Kirklees Direct
Tel: 01484 414746
Email: lucy.taylor@kirklees.gov.ukK Nisar
75, Imperial Road
Edgerton
Huddersfield
HD1 4PGDate: 18-Jan-2022
Our Ref: 2021/94549

TOWN AND COUNTRY PLANNING ACT 1990
TOWN AND COUNTRY PLANNING (GENERAL PERMITTED DEVELOPMENT) (ENGLAND)
ORDER 2015 – SCHEDULE 2, PART 1, CLASS A.1 (g)
AT: 75, Imperial Road, Edgerton, Huddersfield, HD1 4PG
Prior notification for erection of single storey rear extension

Front & Rear Elevations
Proposed

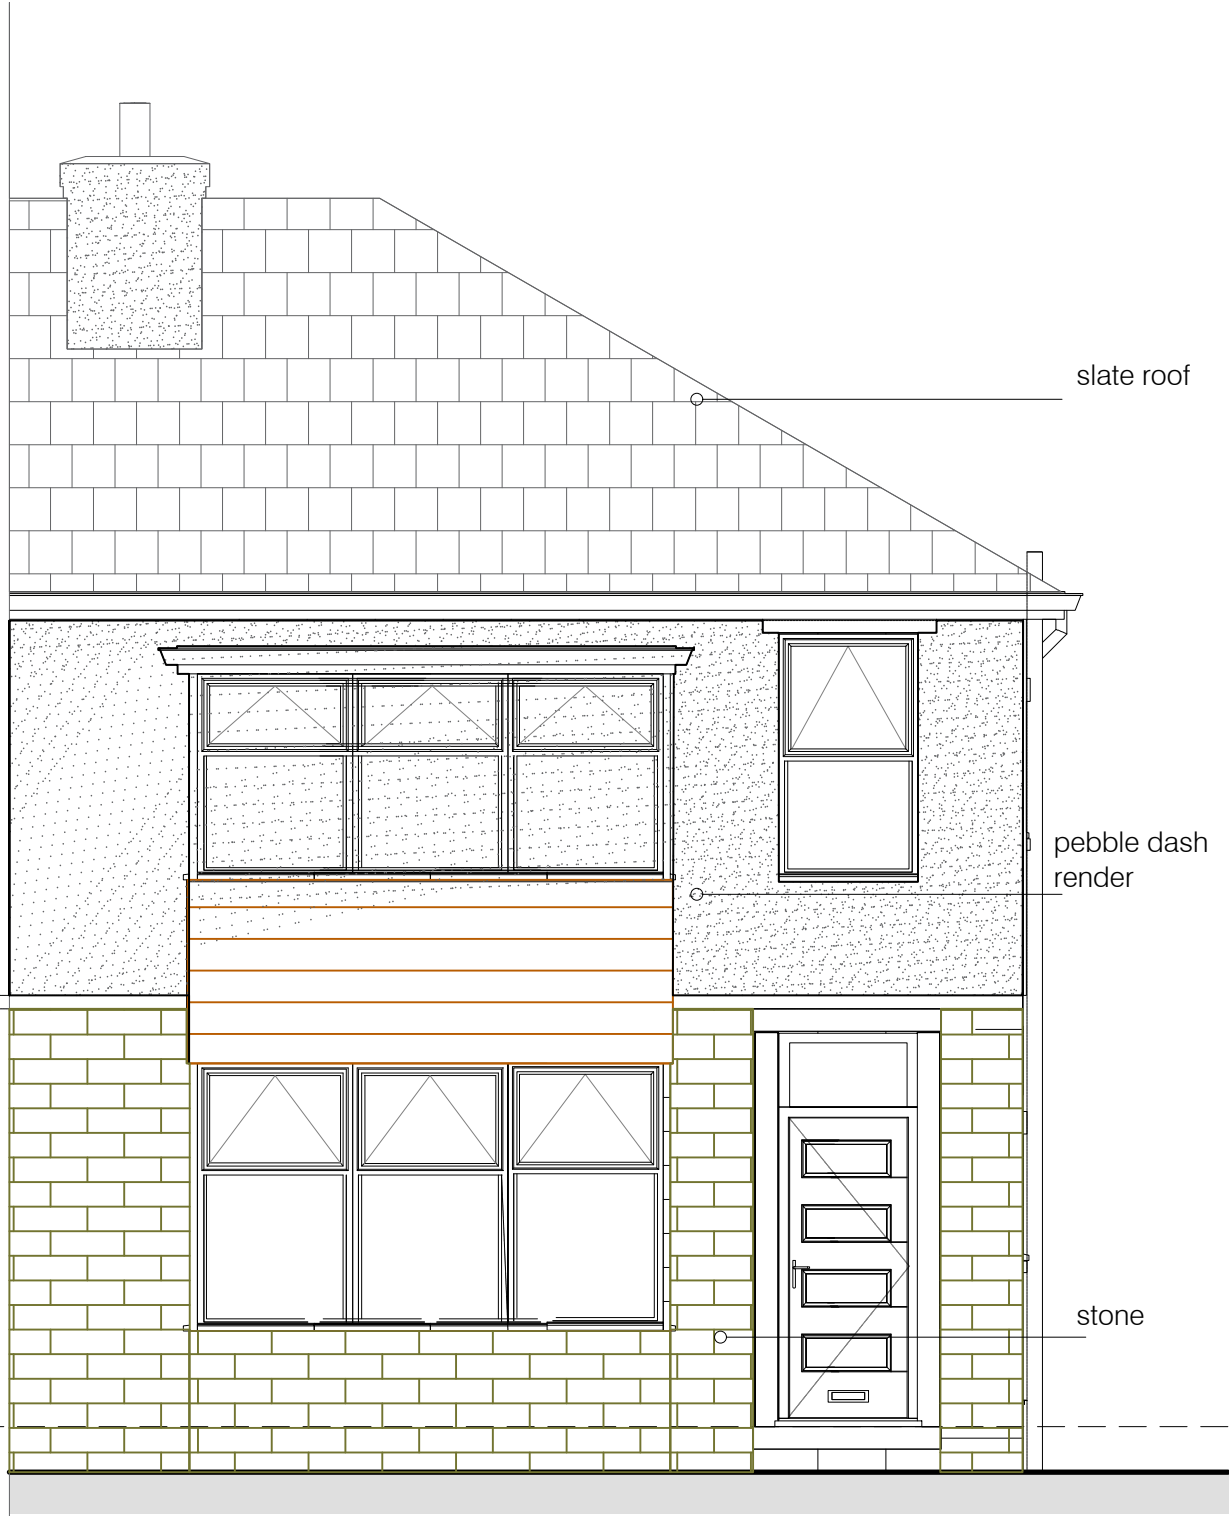
The proposal is for erection of single storey rear extension. The extension projects 6m beyond the rear wall of the original dwelling house. The maximum height of the extension is 4m, the height of the eaves of the extension is 3m

The proposal fails to comply with sub-paragraph j(iii) of Class A, Part 1 of Schedule 2 of the Town and Country Planning (General Permitted Development) Order 2015 (as amended) by reason that the proposed extension would project beyond an original side elevation of the dwellinghouse (original rearward projection) and have a width greater than half the width of the original dwellinghouse.
